CITY OF ALBUQUERQUE

Re: Holly Retail Center
Grading and Drainage Plan
Engineer's Stamp date 1-30-12 (C20/D063)

GD-2

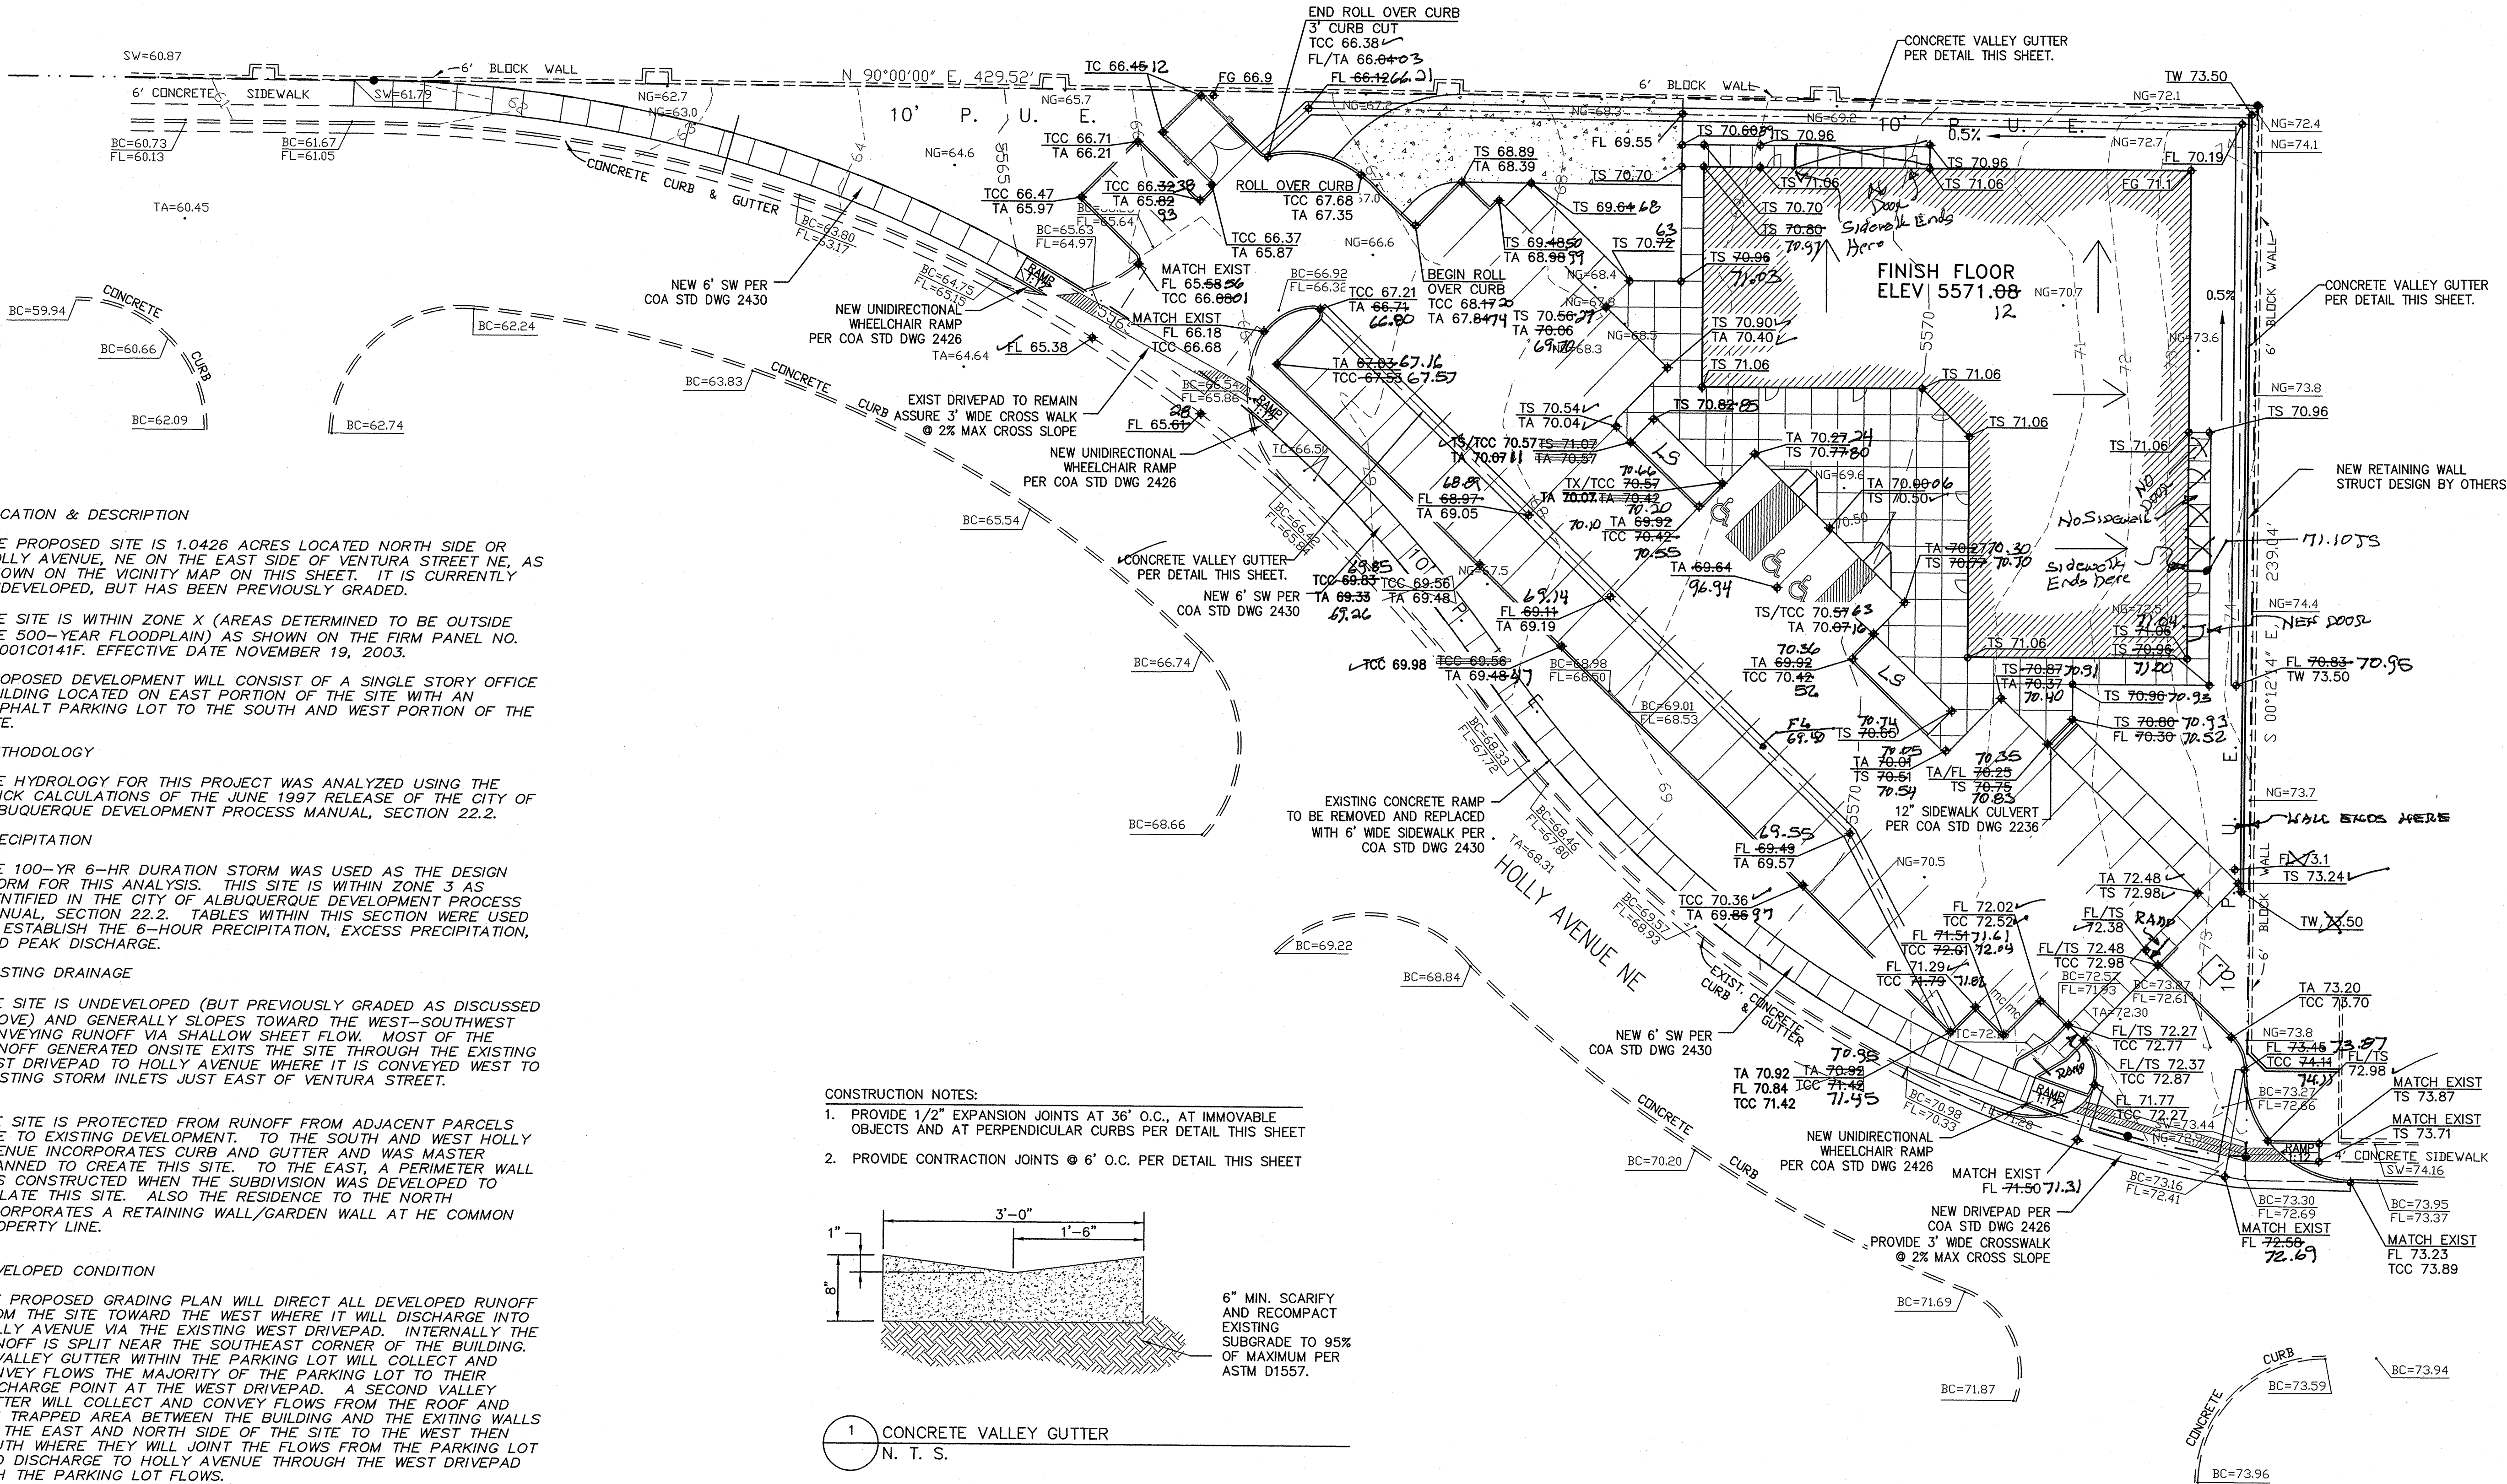
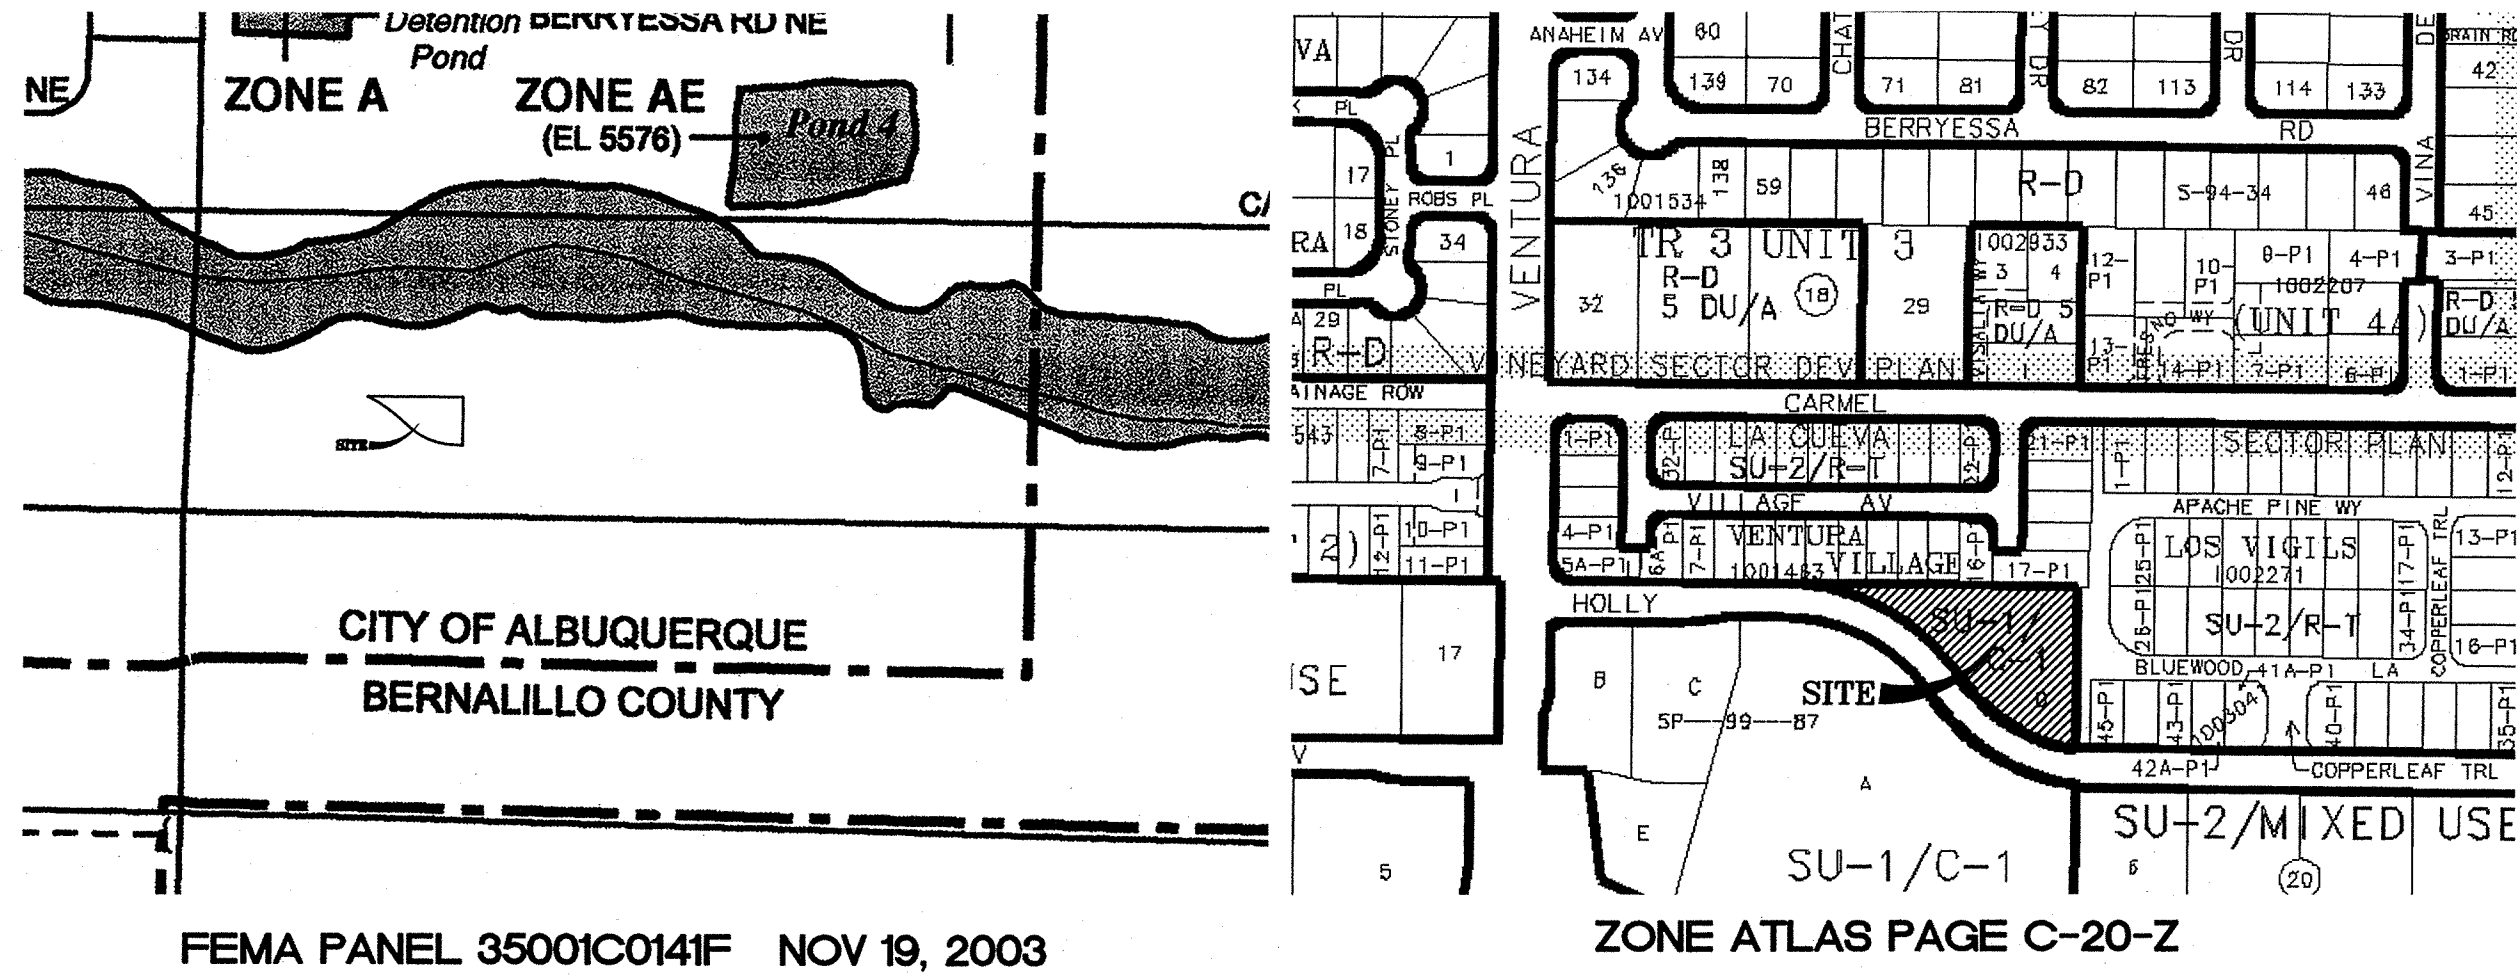
Based upon the information provided in your submittal received 1-31-12, the above referenced plan is approved for Building Permit. Please attach a copy of this approved plan to the construction sets prior to sign-off by Hydrology. and on this set please change plan from Conceptual Grading Plan to Grading Plan.

To obtain a permanent CO, Engineer Certification of the Grading Plan per the DPM check list is required. On this set please change plan from Conceptual Grading Plan to Grading Plan.
